**RE: MODIFICATION TO SSD-8989 CATHERINE MCAULEY COLLEGE  
507 MEDOWIE ROAD, MEDOWIE NSW 2318**

Per our correspondence this letter outlines the applicant's response to the Request for Information issued 15 July 2025.

**Attachment 1: Updated Landscape Plans prepared by Terras Landscape Architects**

L02

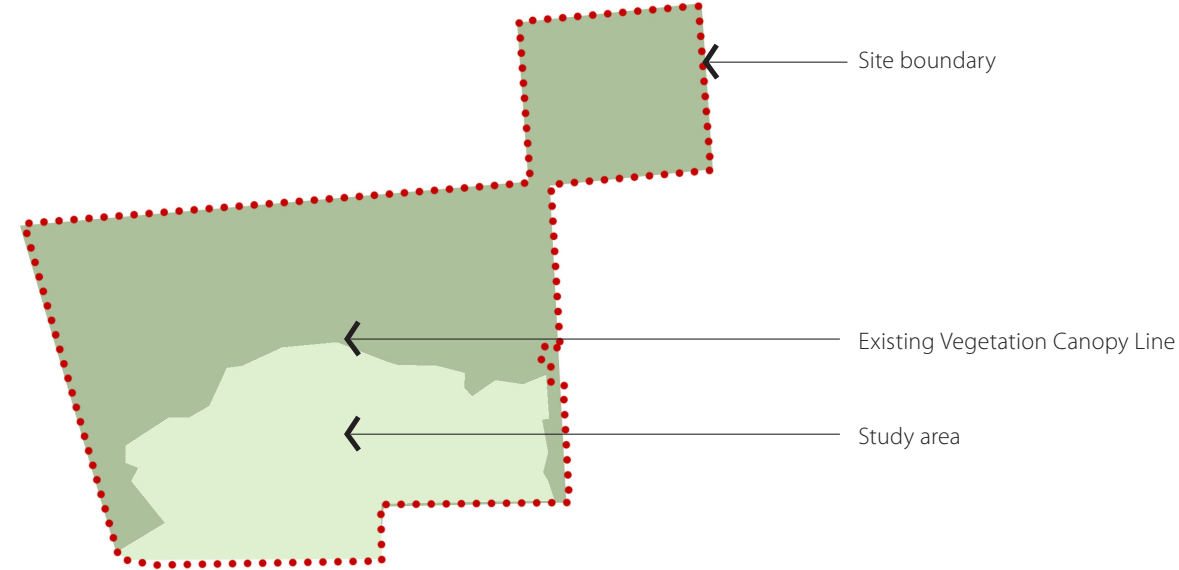
*The submitted planting schedule includes broader changes to the project's approved species mix, with differences in both species count and composition. The submitted schedule appears to introduce a new species mix that was not part of the modification application. If this revised planting schedule is intended to replace the previously approved mix, the Department requires*

*justification to explain how the proposed species selection aligns with the site's biodiversity values, including any benefits or improvements compared to the approved plan.*

- clarification as to whether the revised planting schedule is intended to supersede the previously approved schedule

- if a revised species mix is proposed, written justification from a suitably qualified person outlining how the changes support or enhance the site's biodiversity values, and how the new mix compares to the approved schedule.

For clarity, it is confirmed that the revised planting schedule is near identical to that approved under Modification 3 (extract below). The only change in the revised schedule is the addition of one *Glochidion ferdinandi* (New tree 2) and provision of one *Angophora costata* (New tree 1).

As above, the species mix is near identical to that approved under Modification 3. No further consideration is required.

DRAWN: MA	DATE: 16/07/2025	SCALE: AS SHOWN
JOB NUMBER: 13790.5	PHASE: SD	D No: REV: L04 E

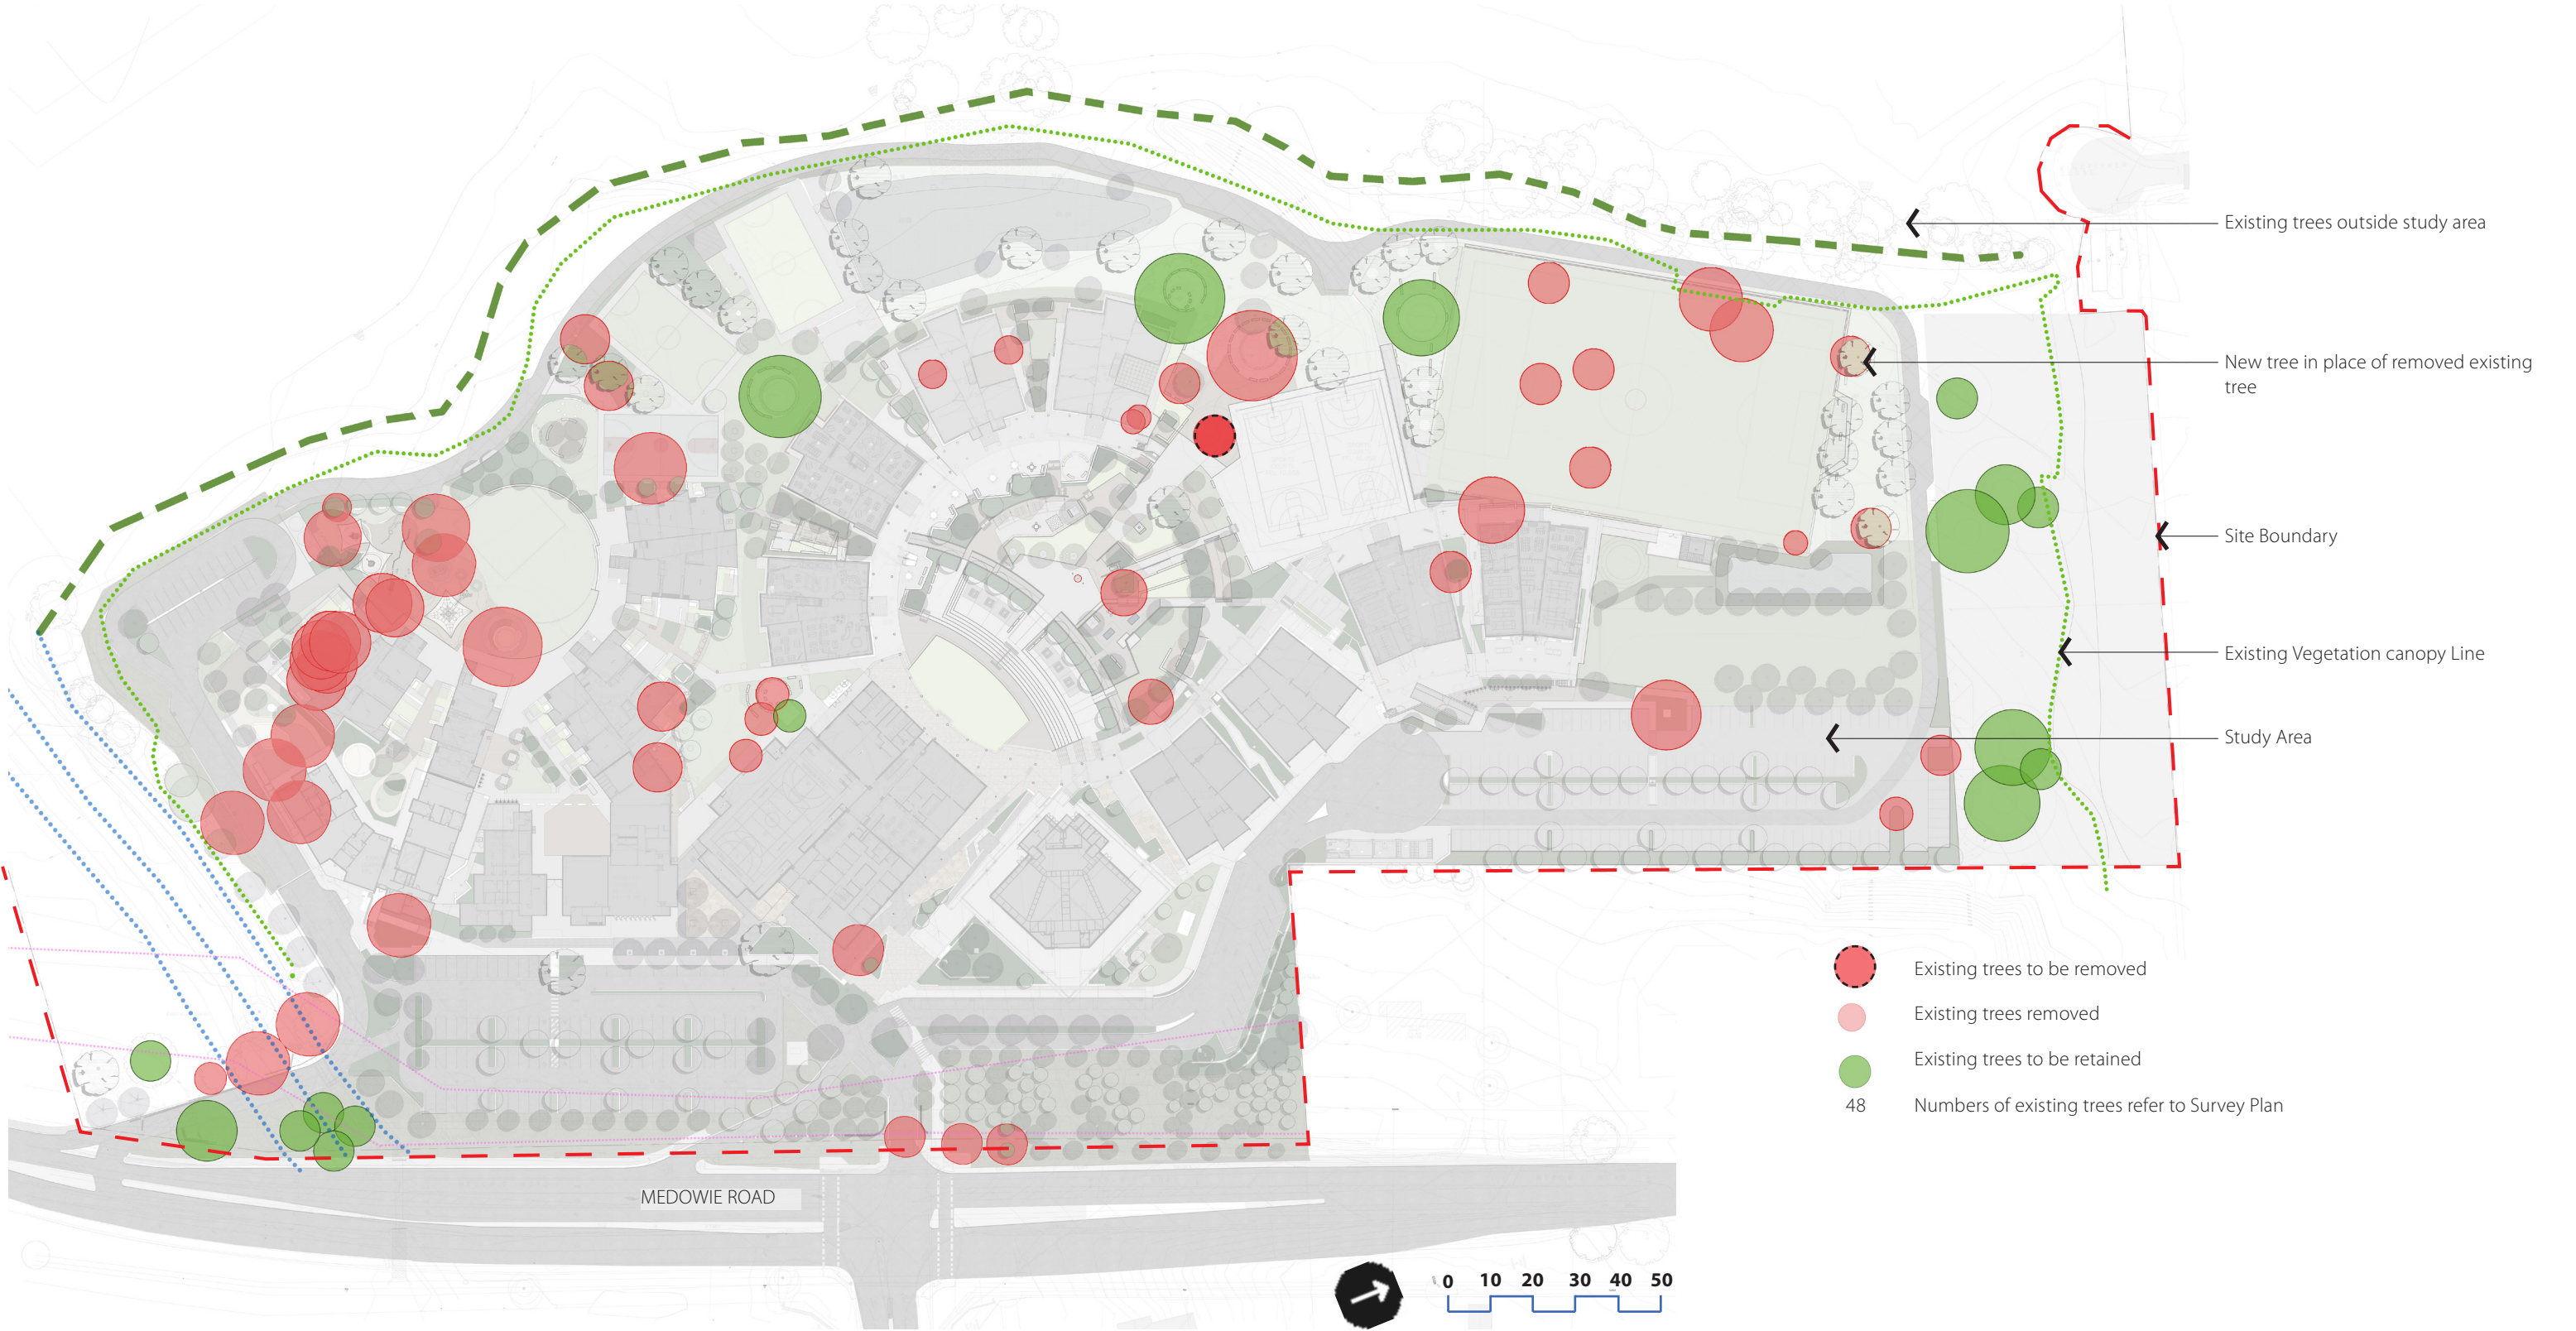
*The 2 replacement trees are labelled 'New tree 1' and 'New tree 2', but their respective species have not been identified. Additionally, 'New tree 2' is proposed in close proximity to Tree 26, which is to be removed due to potential impacts from the construction and siting of the COLA. The COLA is not shown on the submitted landscape plans, making it unclear whether there would be spatial conflict with the proposed tree at planting or maturity. No information has been provided to demonstrate the suitability of this location for 'New tree 2', particularly in relation to the footprint of the COLA.*

- *identification of the species proposed for 'New tree 1' and 'New tree 2'*

- *justification for the location of 'New tree 2', including confirmation that the proposed planting location is compatible with the footprint and functional use of the proposed COLA*

- *confirmation that both replacement trees are endemic to the local area and support the biodiversity values of the site*

- *details of the height of each tree at planting and at maturity*

The landscape plans have been updated (**Attachment 1**) to include species information for the two replacement trees on sheet L05.

Proposed 'New tree 2' has been relocated to be well outside the proposed COLA area. The COLA area is now shown on the plans. This comment is therefore no longer applicable.

As noted previously, species details are provided in sheet L05 of the updated landscape plans being 'New tree 1' *Angophora costata* and 'New tree 2' *Glochidion ferdinandi*.

As noted previously, 'New tree 2' has been relocated well outside the COLA area. This comment is therefore no longer applicable.

As noted previously, species details including height (both at planting and maturity) are provided in sheet L05 of the updated landscape plans being:

- 'New tree 1':
  - At time of planting – 2.5-3.5m
  - Maturity – 15-25m
- 'New tree 2':
  - At time of planting – 2-2.5m
  - Maturity – 8-12m
